A38 Derby Junctions Development Consent Order

Scheme Number TR010022

8.55 Actions Arising out of Issue Specific Hearing 2 on 11 December 2019 for Deadline 3

December 2019

### Entry/Egress with A38 NB Diverge Slip road Sketch

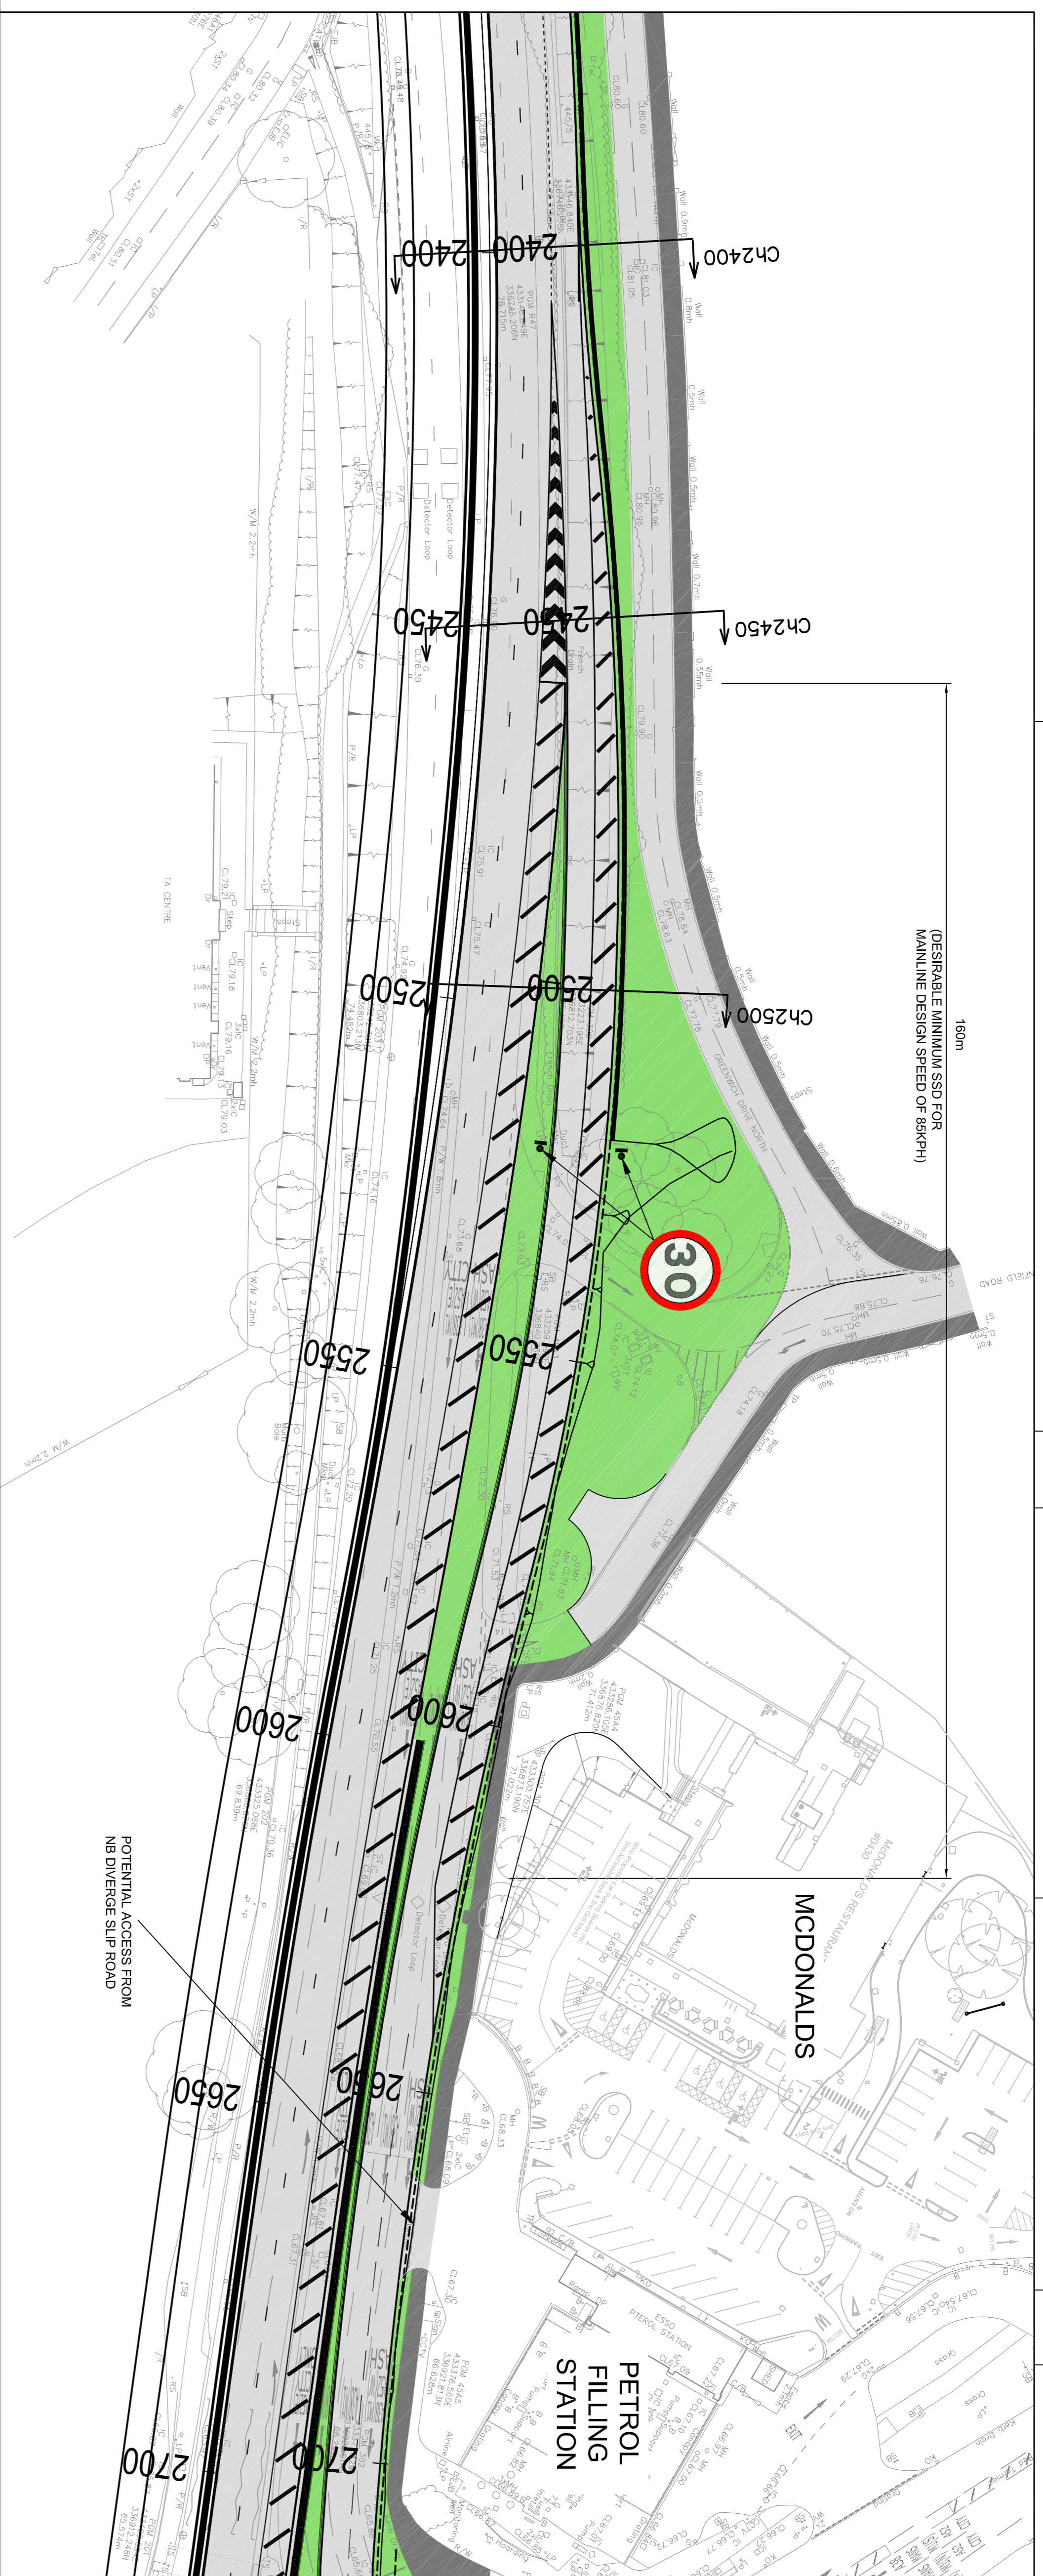
No	Reference	Issue or Question	Applicant's Response
	<p>McDonald's WR [REP1-045] McDonald's draft SoCG [REP1-046] Applicant comments [REP2-020]</p>	<p>g) How would entry to the site from the proposed A38 slip road impact on highway safety. How would the absence of such an access impact on the viability of the businesses? h) Update on the provision of 'roadside facilities' signage.</p>	<p>f) A check with the Land Registry confirms that there are appropriate rights, by way of a conveyance dated 1982, to allow those who need to access the filling station to cross the land owned by McDonalds which abuts the highway at any time, day or night. Highways England believes the proposed Scheme will not change these existing arrangements; however, following EG's comments further investigations will be carried out to confirm the position.</p> <p>McDonald's states it does not have rights to cross over the adjoining Euro Garages site. The Works rely on McDonald's taking deliveries by crossing over land which it neither owns nor has rights over; this is problematic and allows an adjoining landowner to control the viability of the restaurant.</p> <p>Highways England notes it was advised by McDonald's that this arrangement is how the delivery vehicles currently operate. The scheme proposals would not change the arrangements that currently exist.</p> <p>g) Highways Design Standard CD 122 states "Direct accesses and priority junctions shall not be provided on connector roads" ('connector roads' includes slip roads). This is a safety consideration as traffic slowing down to use the access is not compatible with higher speed traffic leaving the trunk road on the slip road as this could result in shunt type collisions.</p> <p>Providing the egress onto the slip road is proposed by the Scheme (as has been agreed in principle with Highways England's safety specialist after extensive discussions); both the filling station and McDonald's will be able to exit the site by this means (as well as onto the A52) – this arrangement is essential to allow fuel tankers to be able to</p>

No	Reference	Issue or Question	Applicant's Response
			<p>exit the site (they would enter from the A52 and there is insufficient space within the site to be able to turn around to exit back on to the A52)</p> <p>h) The site does not currently qualify for designation as a Trunk Road Service Area (TRSA) and is not likely to qualify after construction of the scheme due to insufficient toilet facilities, Lorry and Coach parking. In order to enable the provision of roadside signage, the site would need to be a designated TRSA. Highways England are currently investigating the possibility for a departure to the TRSA standard to allow advance signage for this site.</p>
